**Consultation Response from KC,
Lead Local Flood Authority**

2025/90689 Penistone Road/, Rowley Lane, Fenay Bridge, Huddersfield, HD8 0JS

Discharge of details reserved by conditions 16 (temp drainage), 25 (retaining walls), 26 (surface water attenuation pipes), 31 (road network) on previous permission 2020/92307 for outline application, including the consideration of access, for erection of residential development (up to 75 units)

The document entitled Homes By Honey : **Condition 16 – Temporary Drainage Strategy** has been assessed by Flood Management.

Temporary Drainage Strategy

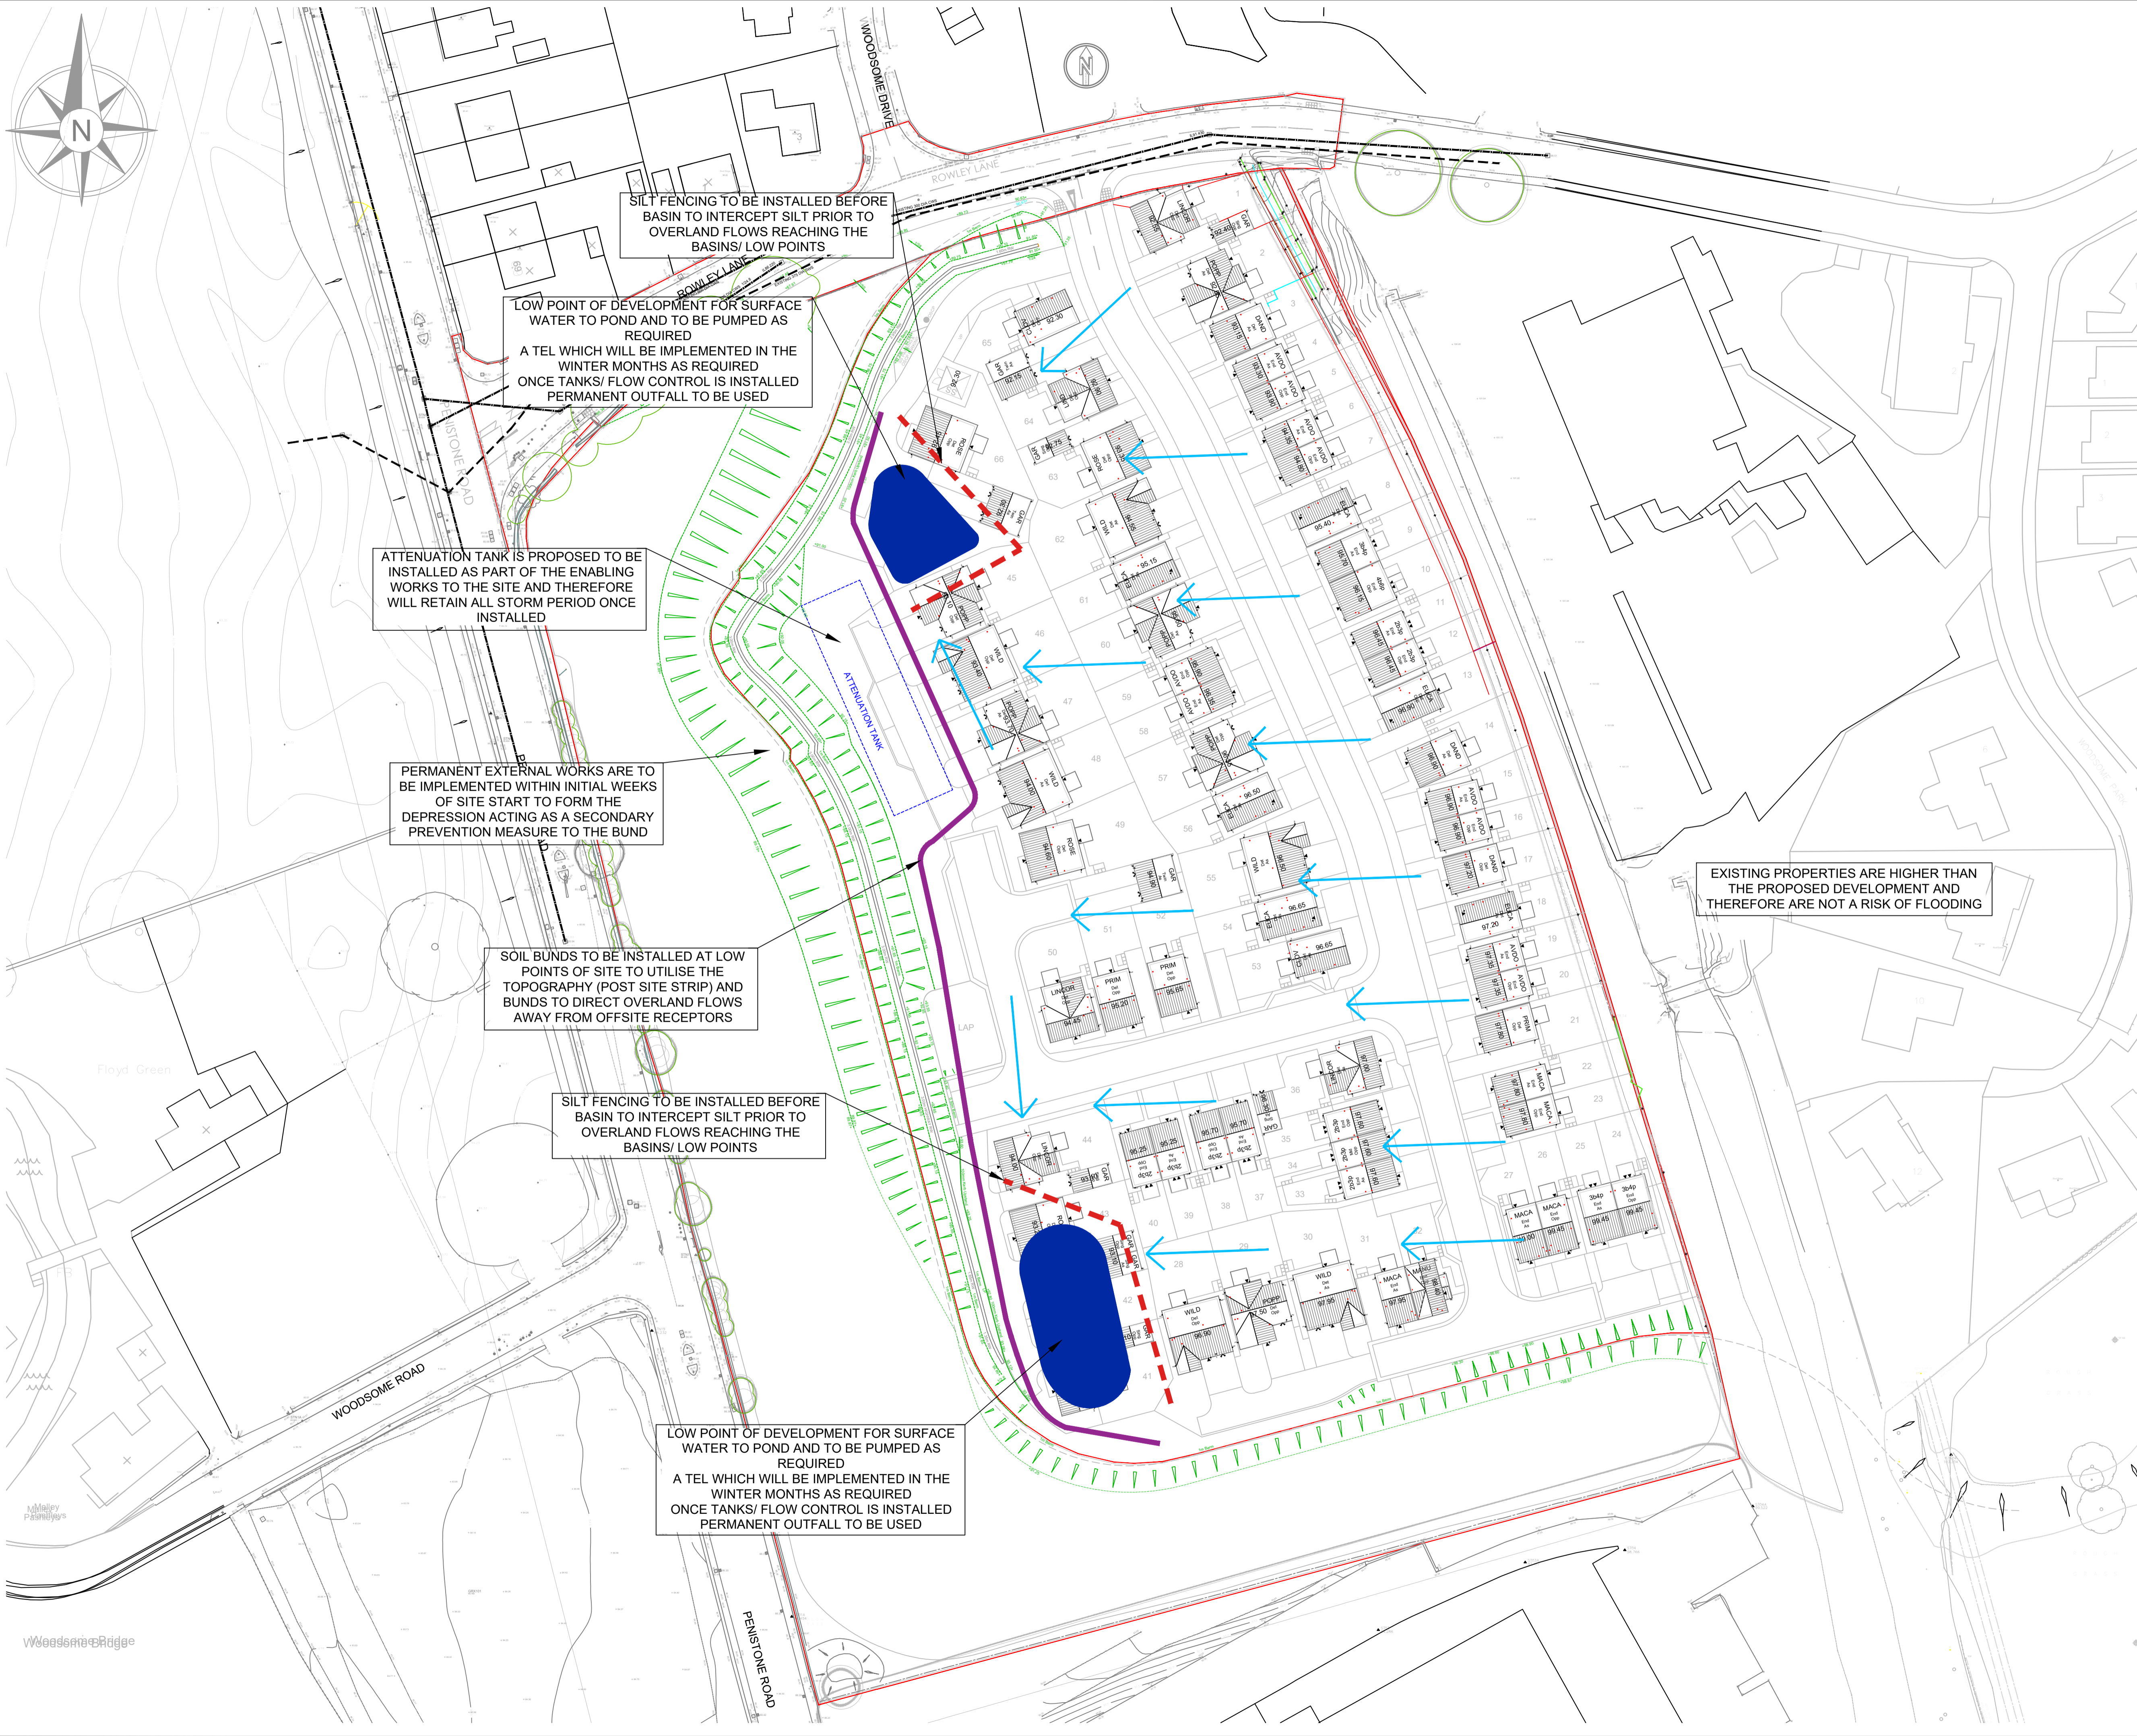
Whilst the principles of a two phased approach are welcomed, examining flood risk and pollution post site strip and then post installation of the attenuation tank, the former phase required an assessment of the volume of run off generated in the 1 in 2 year 6 hours storm event. This is explicitly stated in the wording of the condition.

Whilst areas have been identified to store water, no evidence as to their adequacy has been submitted.
